R/226/20/DOC

Woodbine Cottage 1 Mill Lane Rustington BN16 3ED

Approval of details reserved by condition imposed under ref R/93/20/HH relating to Condition No 3 - materials to be used for fenestration (including rooflight).

Side Window

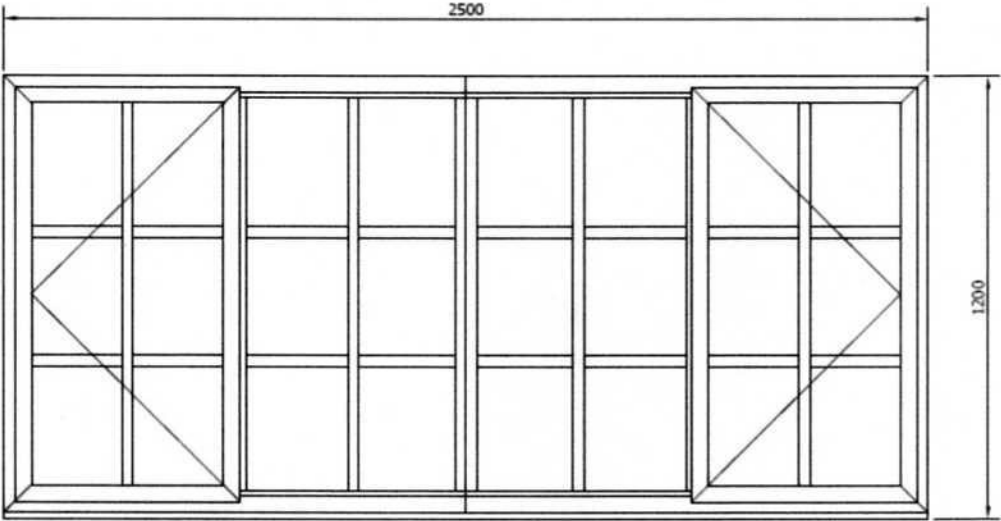
Front Window: It is not clear from the information provided what the glazing system will be. If it is to be double glazed, will the slimmer units be used? I should point out that as the proposal affects a modern extension, the use of the slimmer units would be acceptable. Further, as the application only provides a front elevation drawing of the casement window it is not clear what the glazing bars etc will look like, or what their dimensions will be. This information can be provided in the form of a drawing which shows the section of the window and includes details of the proposed glazing and appropriate measurements.

1. Front Window: Please find attached a response from Demon Designs regarding the front Window – he has reverted to the system designed by ALUK to get the slimmest unit into an Aluminium frame together with making the frame correspond with the original windows on the property. His attached response has provided you with all the relevant information you require. The windows shown have been used on a main principal elevation of a listed property. As previously agreed the window will be white (RAL 9010) to match the remainder on the front elevation.
